Our ref: St Aloysius College - Rozelle Campus (SSD-27208140)

**Subject:** Request for Additional Information

I refer to the State significant development (SSD) application for the St Aloysius College - Rozelle Campus (SSD-27208140). After careful consideration, the Department of Planning and Environment (Department) is requesting that you provide the following additional information:

2A-2B Gordon St - L1

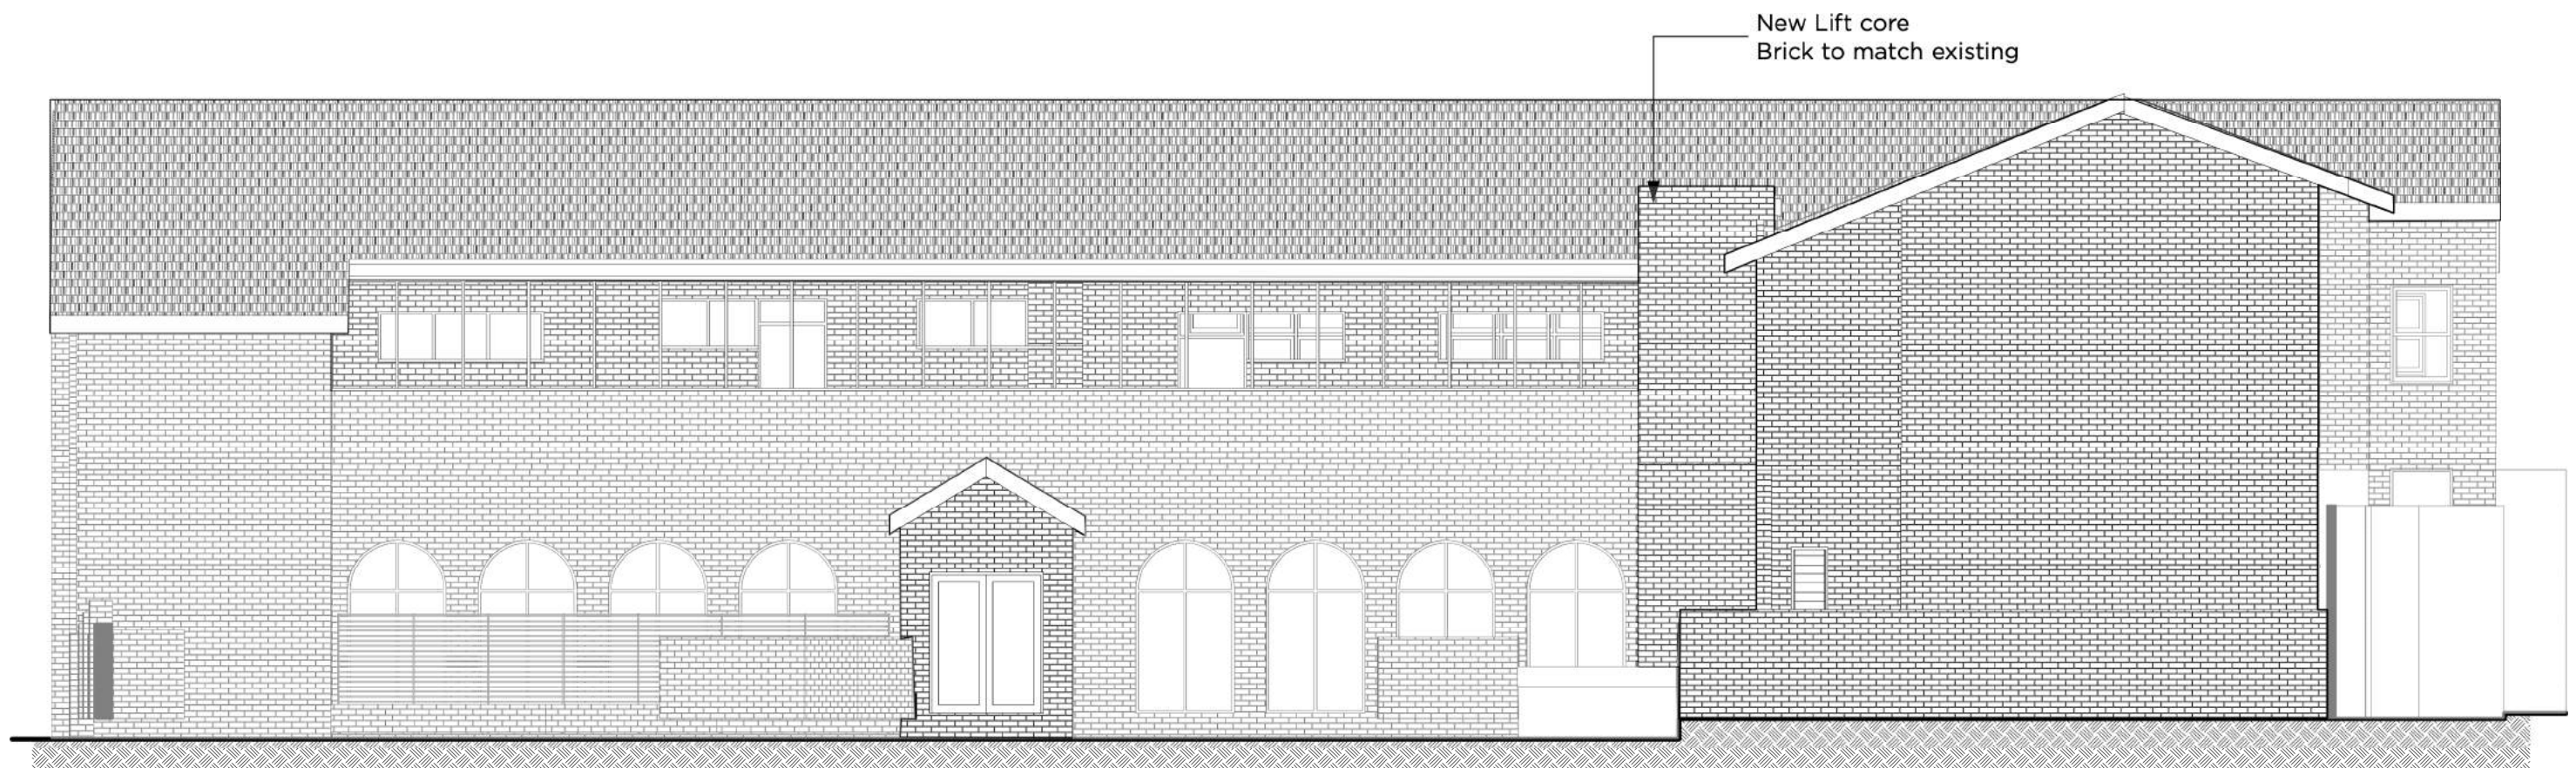
Additional information is required to clarify the location of the existing sanitary facilities within 2A and 2B Gordon Street (Gordon Street site).

In this regard, please note that the proposal includes use of the first floor of the building only. If the students need to access the ground floor for toilet facilities, then details of this section of the ground floor and the connection to the upper floor needs to be provided.

However, the assessment considers the entire building to be 9b and does not acknowledge that the lower floor would be used by another occupant for the purpose of a theatre. While the building classification would likely remain the same, fire separation would be required between the two floors, given the separate uses.

The assessment needs to acknowledge the two separate uses and then provide with fire resistance requirements as well as brief measures for fire separation between the two floors (considering that the development application for the lower floor theatre may not progress, which means no works pursuant to that application would be done).

The assessment also needs to confirm whether such fire upgrades (if any, including floors, ceilings and glazing) would impact on the external façade of the heritage listed building or any other component with heritage significance.
